MN/MR  
15313  
10 August 2015

**SECTION 75W MODIFICATION APPLICATION TO MP 09\_0007 - RESPONSE TO  
SUBMISSION  
STAGE 1 MOORE THEOLOGICAL COLLEGE RESOURCE AND RESEARCH BUILDING**

I write to you in response to the submission prepared by the City of Sydney Council in relation to the proposed S75W modification application to MP 09\_0007. Each of the issues raised in the submission are addressed below.

Drawing No
S75W-3200 C

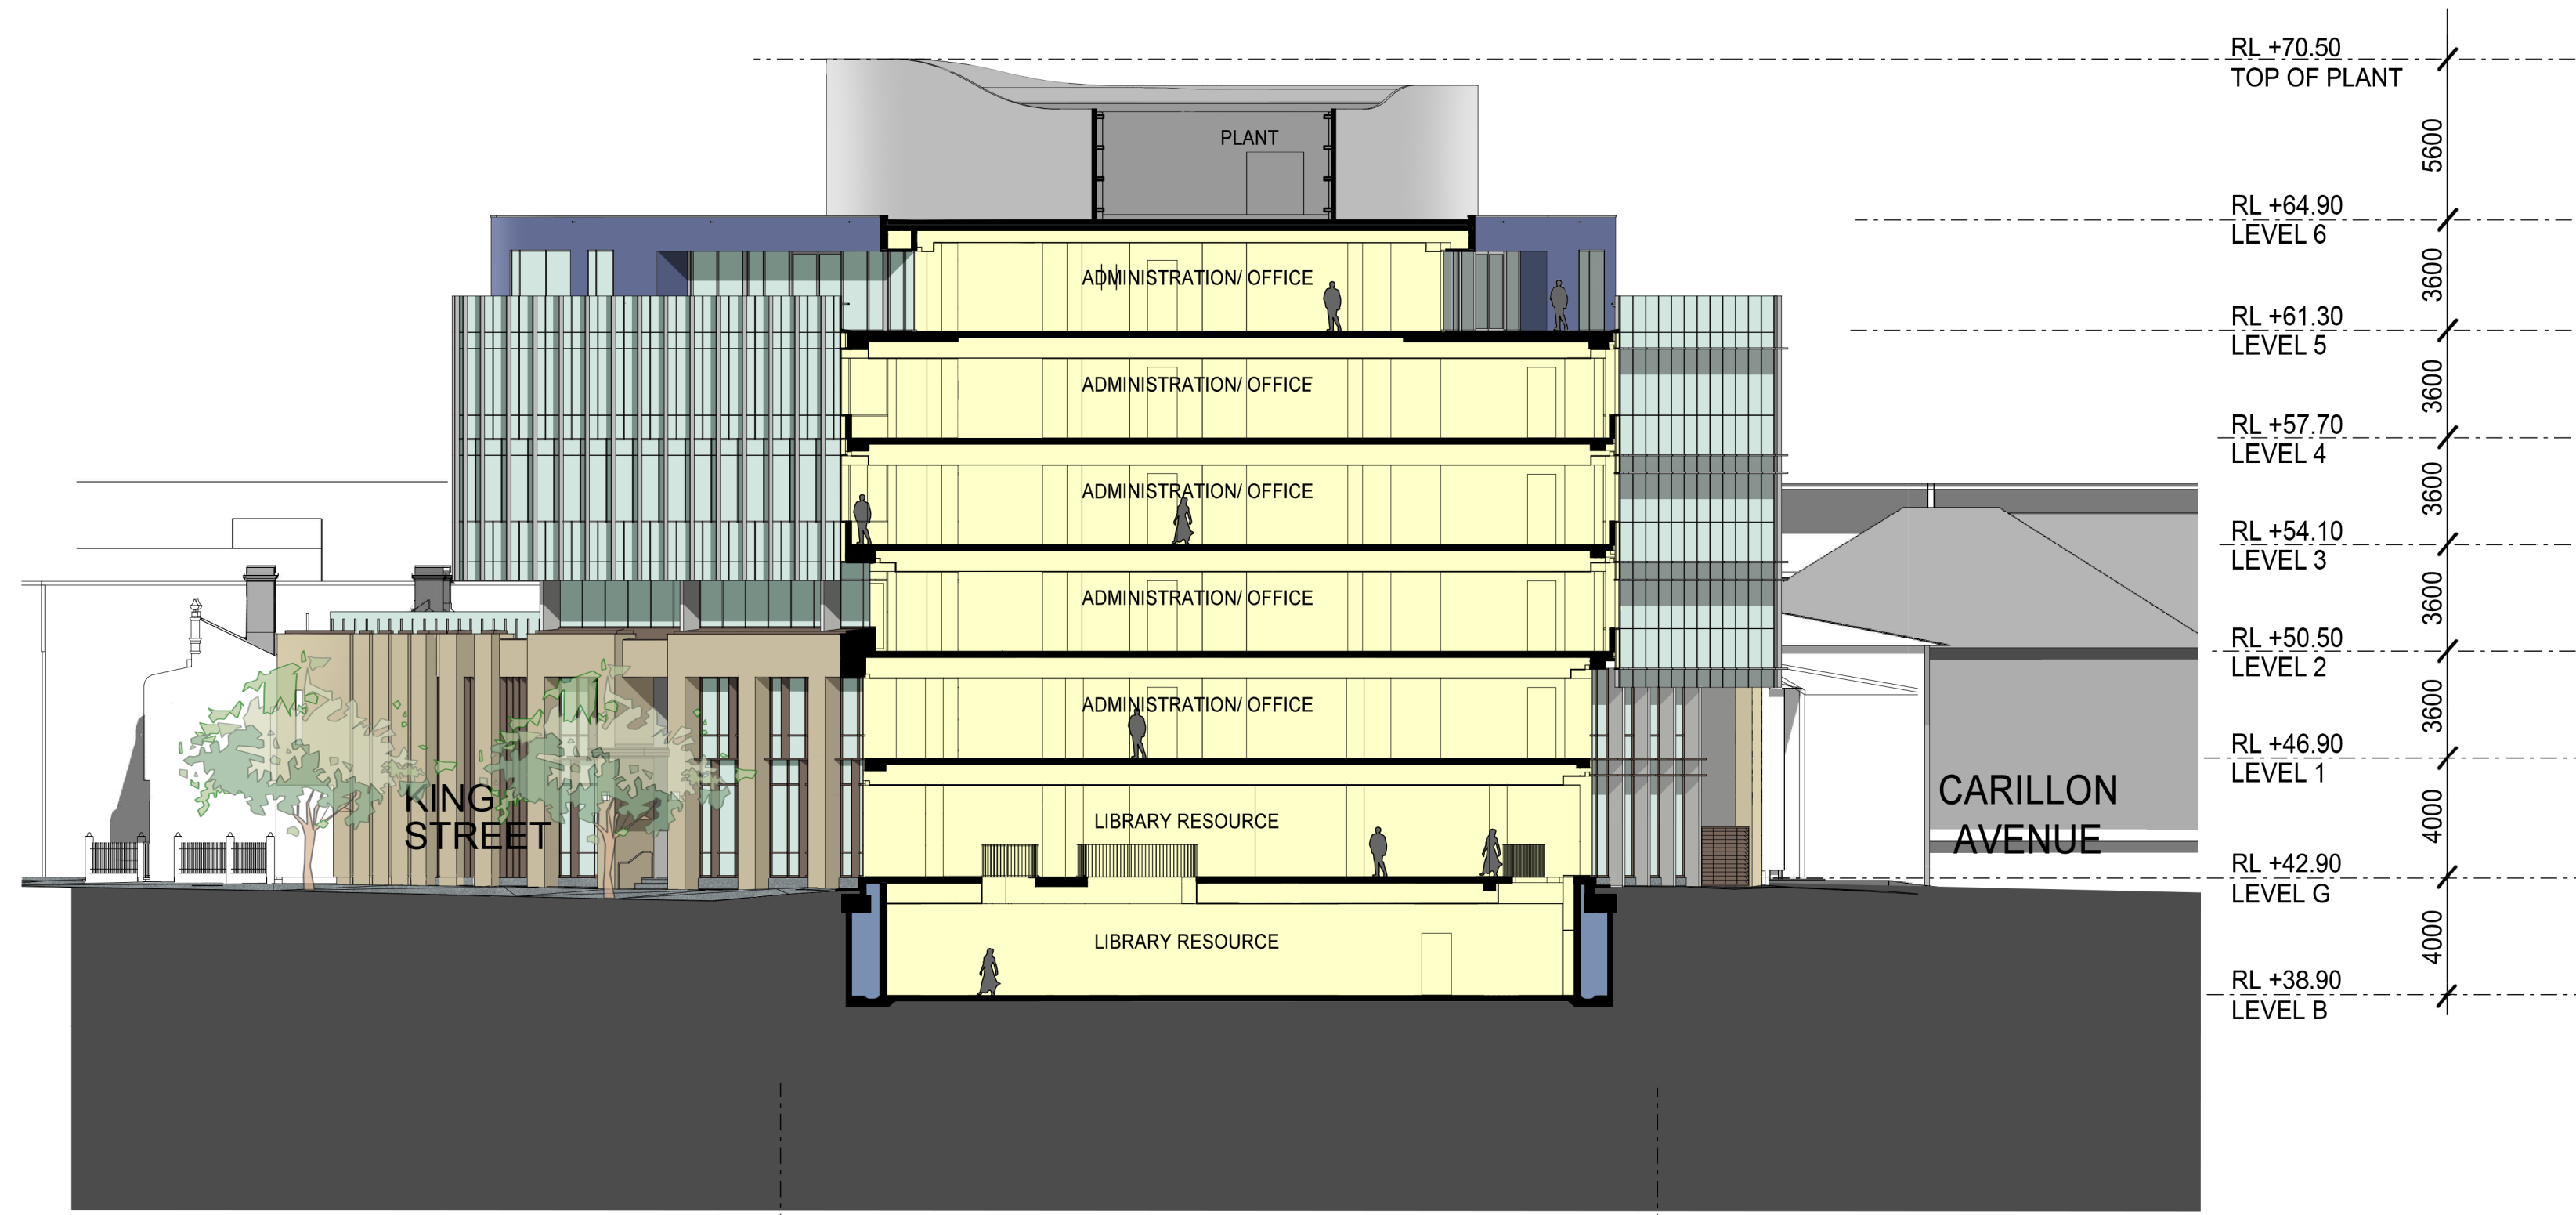
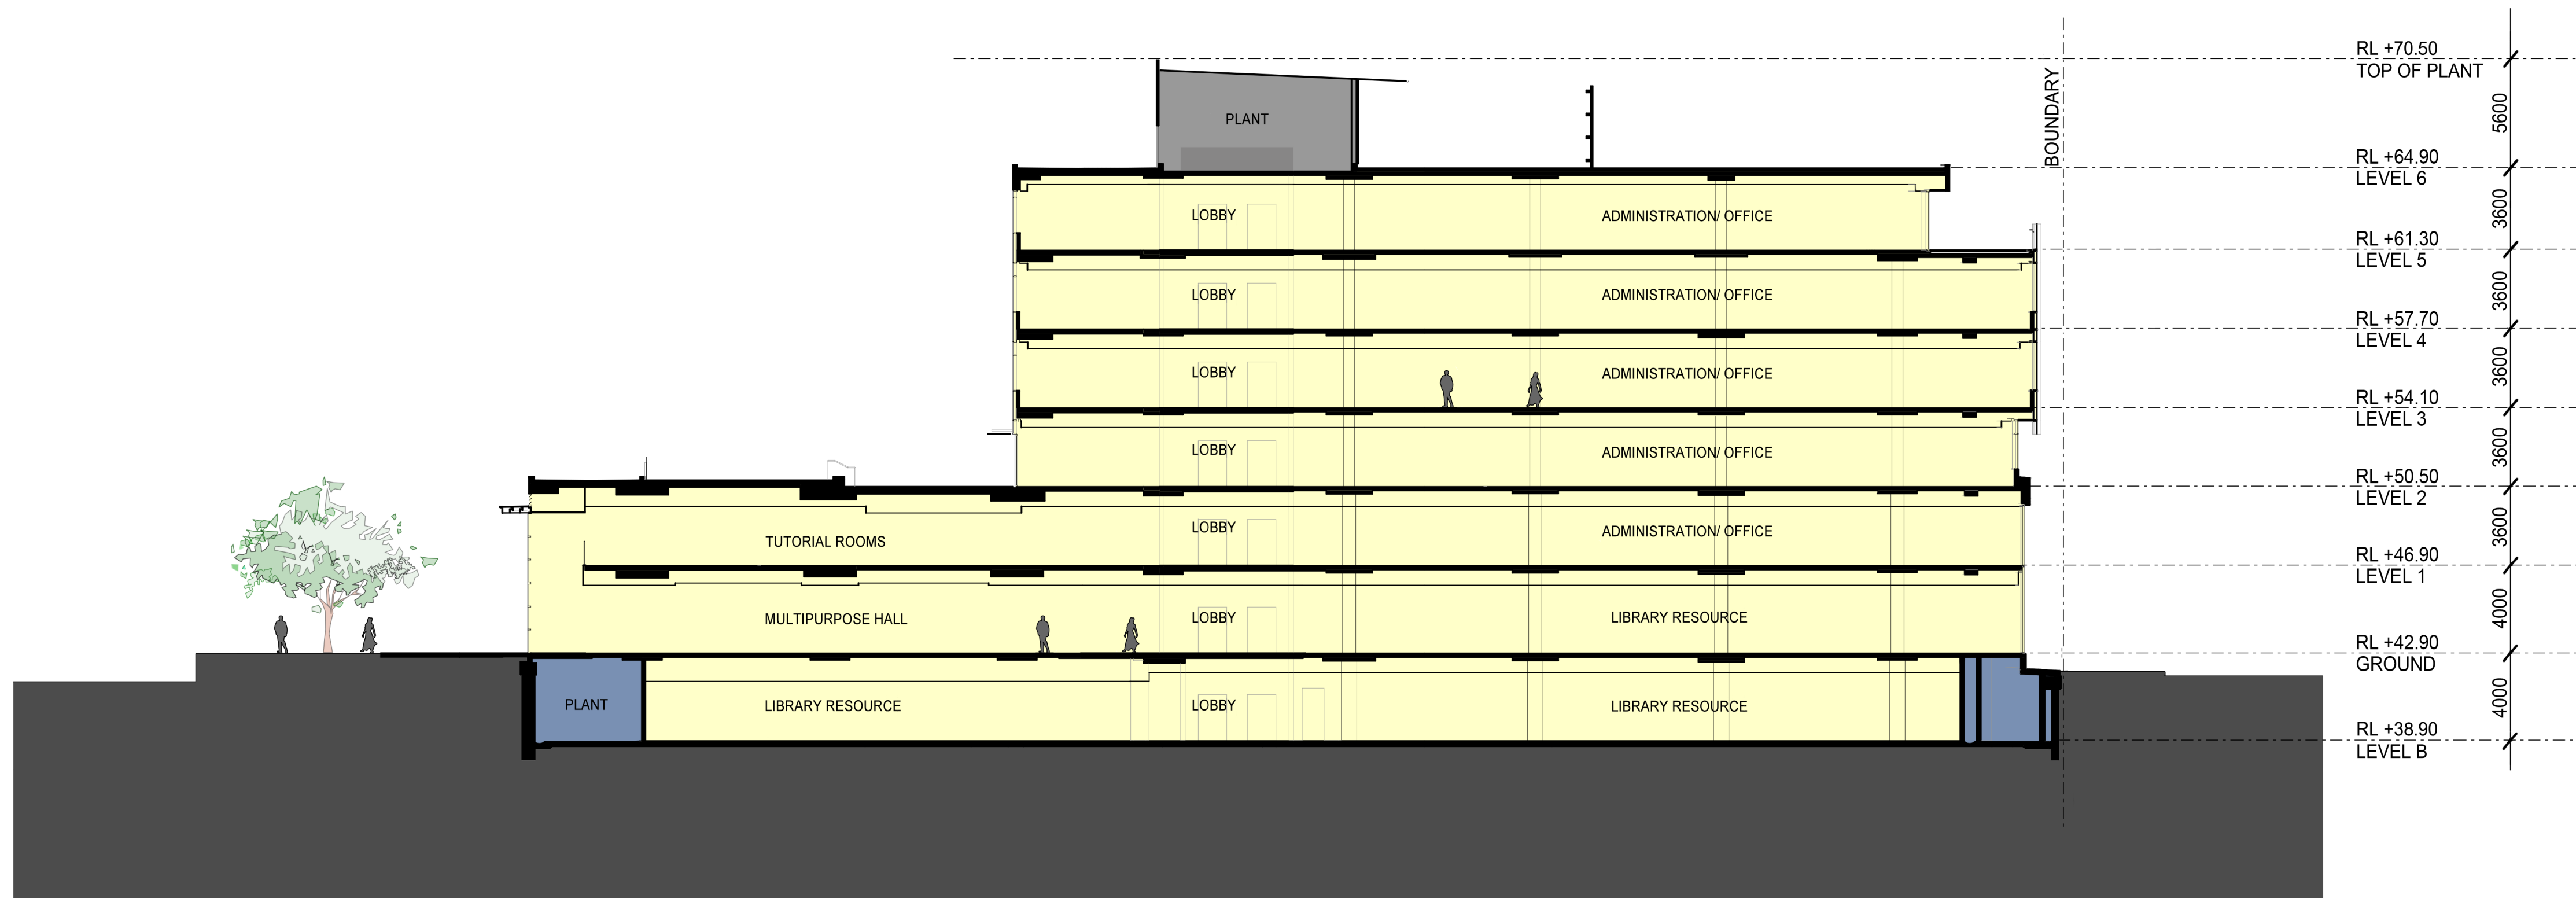
A section plan annotating floor to floor RL levels has been prepared for the modification and is provided at **Attachment A**. As shown in the section plan, the floor to ceiling heights are not proposed to be amended, rather the height of the roof plant is reduced from RL70.6, as approved under MOD 1, to RL70.5 as proposed.
